From: Claire Booth
Sent: 14 September 2012 14:16
To: Jane Tucker
Subject: FW: Consultation on planning application 3/2012/0089 Lanshaw Barn, Woodhouse Lane, Slaidburn

From: Hornby, Mark [mailto:Mark.Hornby@lancashire.gov.uk]
Sent: 14 September 2012 10:24
To: Claire Booth
Cc: ENV EPP Customer Service Area East
Subject: FW: Consultation on planning application 3/2012/0089 Lanshaw Barn, Woodhouse Lane, Slaidburn

I have no objection in principle to this proposal on highway safety grounds. Although the submitted plans do not show the access and parking / turning areas in any detail I am satisfied that suitable arrangements can be made at the site. I would therefore recommend the following conditions be applied to any consent granted:

Proposed Ground Plans

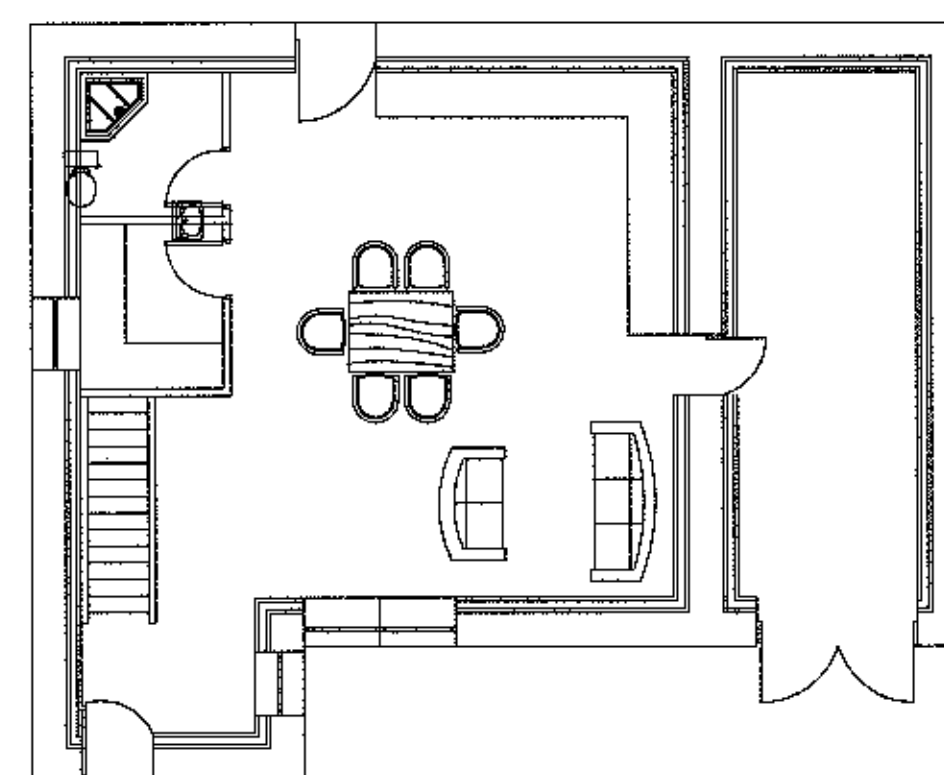
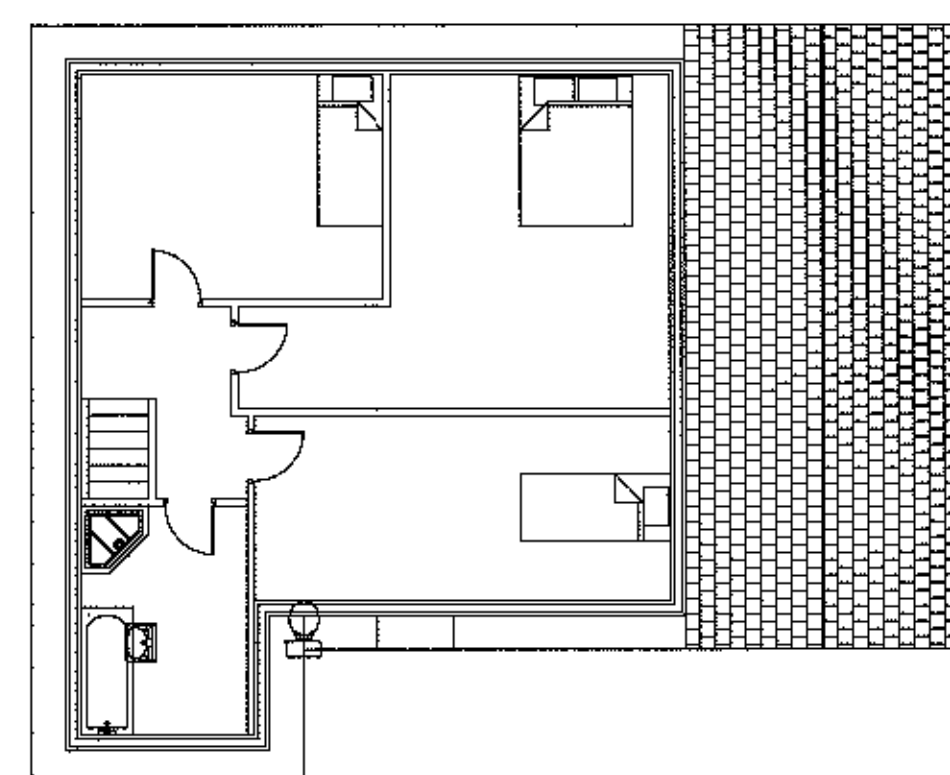
3. The layout of the development shall include parking and turning space sufficient for a minimum of two cars and a scheme detailing this shall be submitted to and approved by the Local Planning Authority in conjunction with the Highway Authority before any works commence on site. Reason: In the interests of highway safety.
